Recommendation Report for Planning Permission for Works or Extension to a Dwelling

REF NO: LU/232/15/HH

LOCATION: 44 Esher Drive
Littlehampton

PROPOSAL: Side extension. This application may be determined by Littlehampton Town Council under delegated powers.

15/4279/2

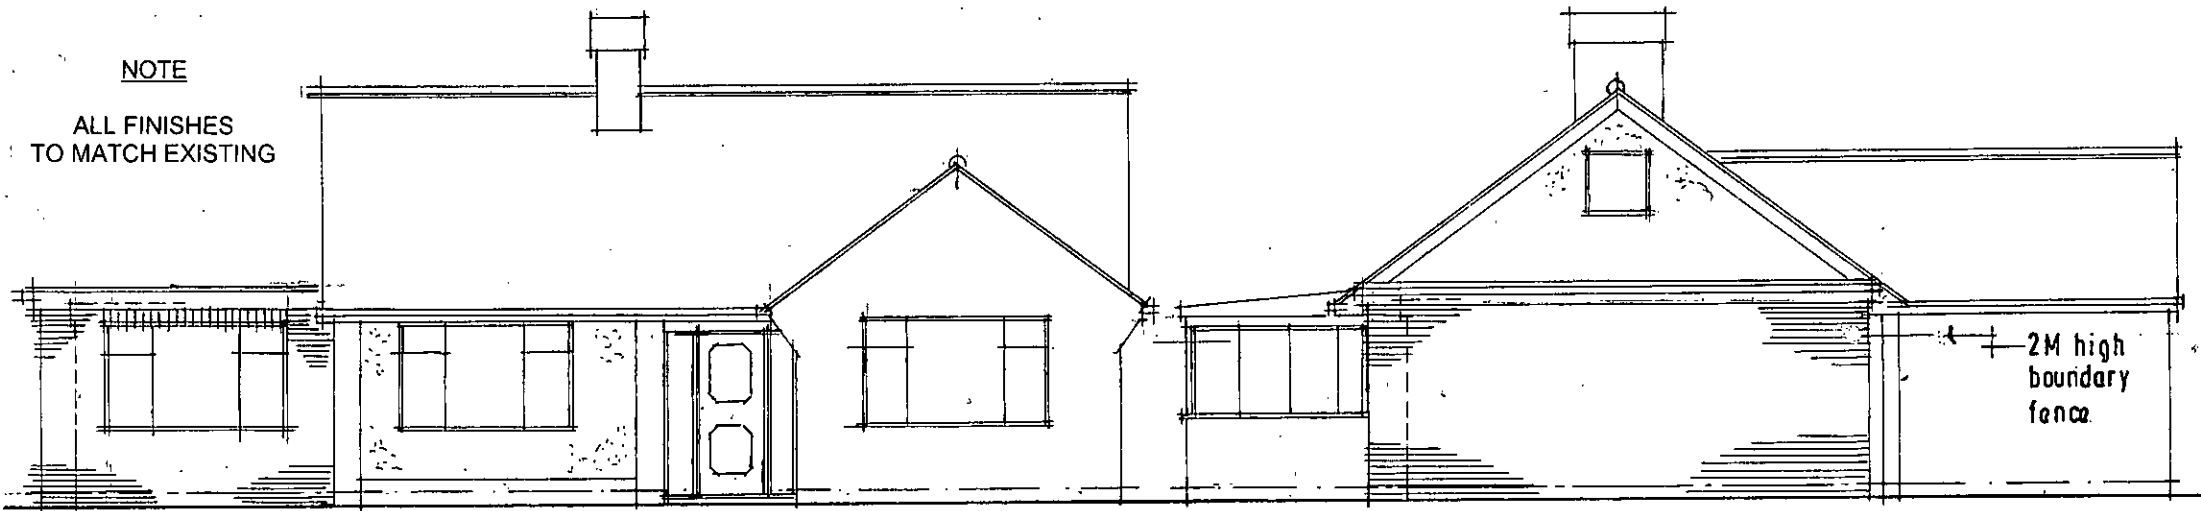
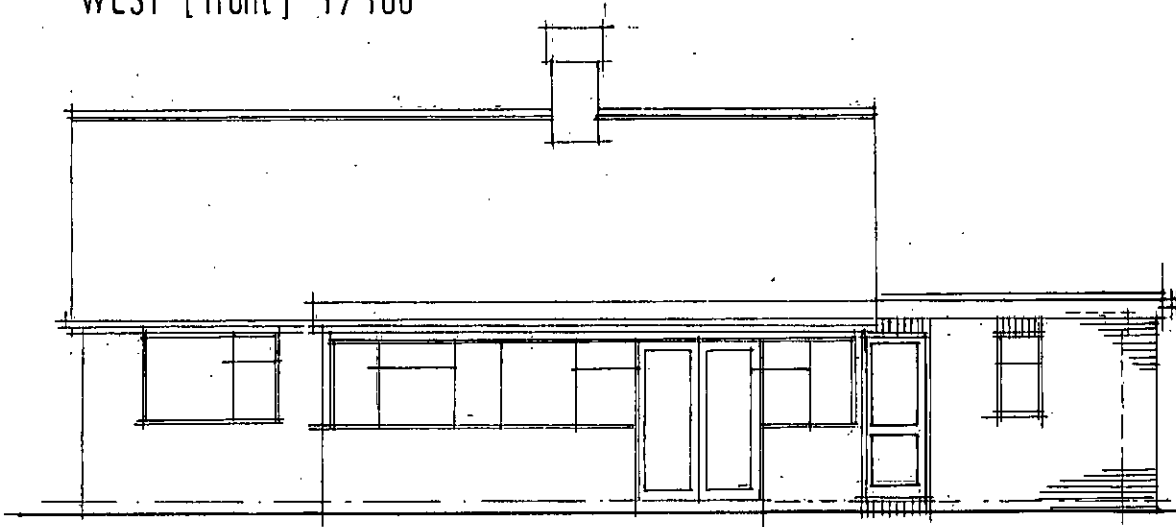
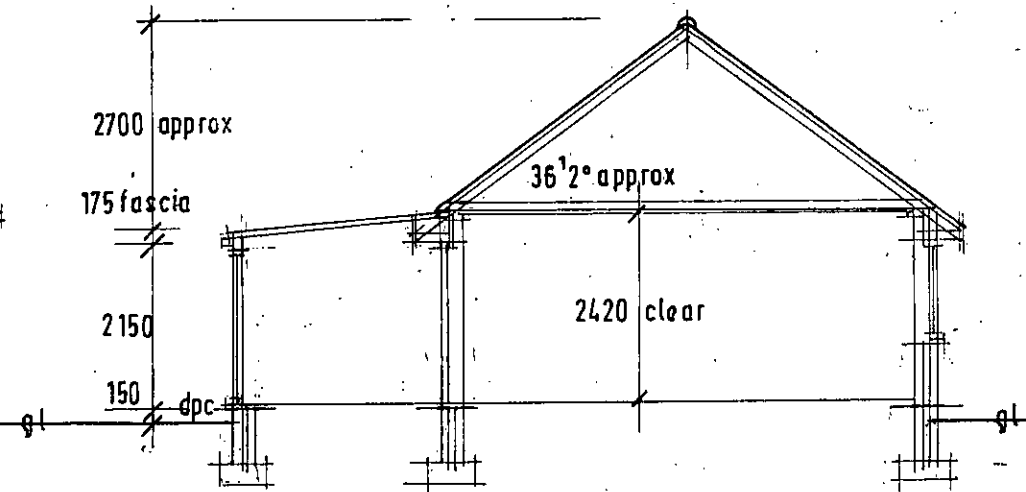
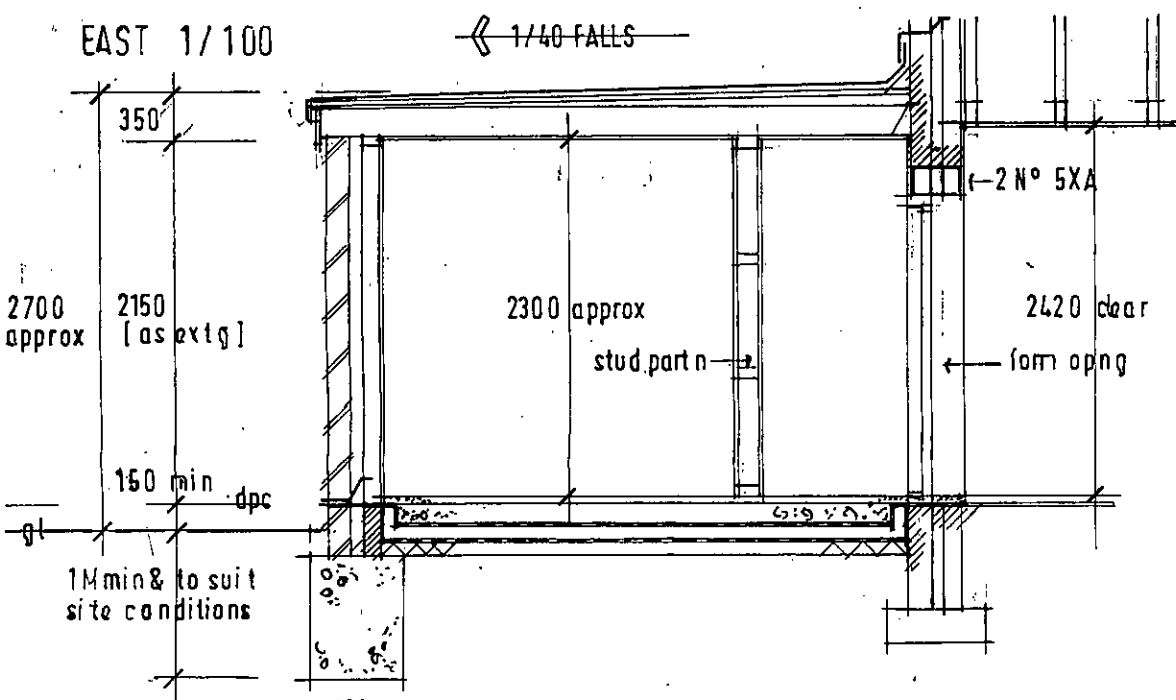
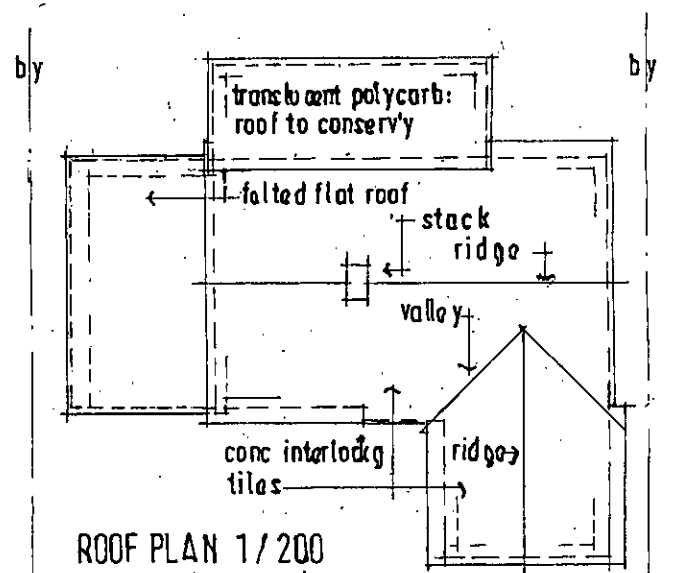
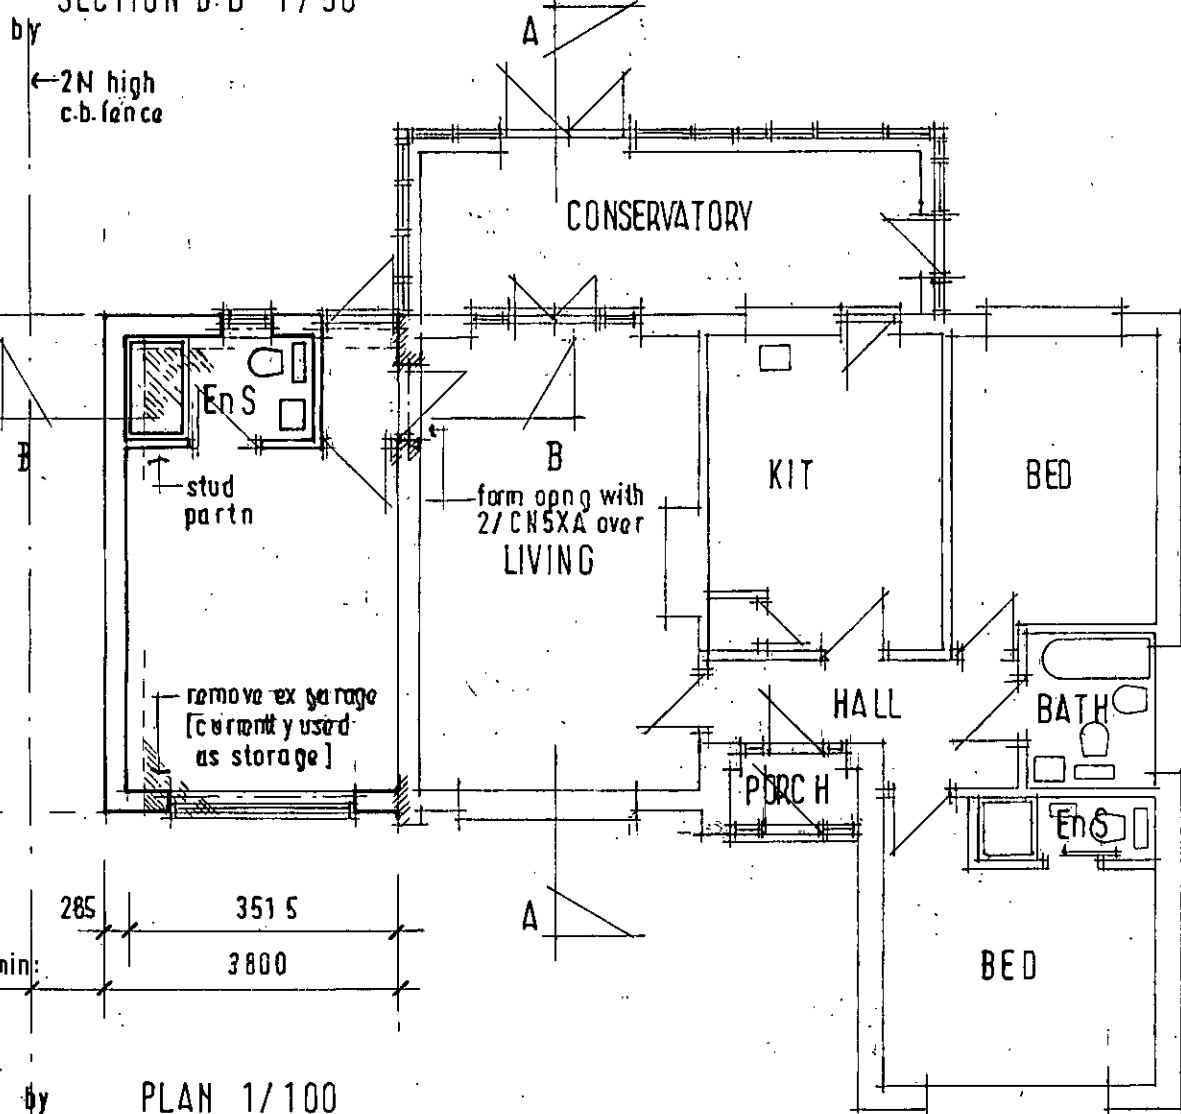
The proposal is for a side extension extending 3.8 metres from the side elevation into the side garden to within 1 metre of the side boundary fence.

The proposal would not appear significantly different to the existing garage in form as it would be just 20 cm higher (at 2.8 metres in height) and 50 cm wider. The height of the proposed roof is

substantially lower than the main dwelling roof and as such it is considered to be subservient to the existing dwelling.

Only 80 cm of the roof would show above the back garden fence of the property to the side and rear and would be set back at least 1 metre from the boundary and the materials of construction are intended to match that of the existing building and would be subject of a planning condition if approved.

- 3 The materials and finishes of the external walls and roof of the building hereby permitted shall match in colour and texture those of the existing building.
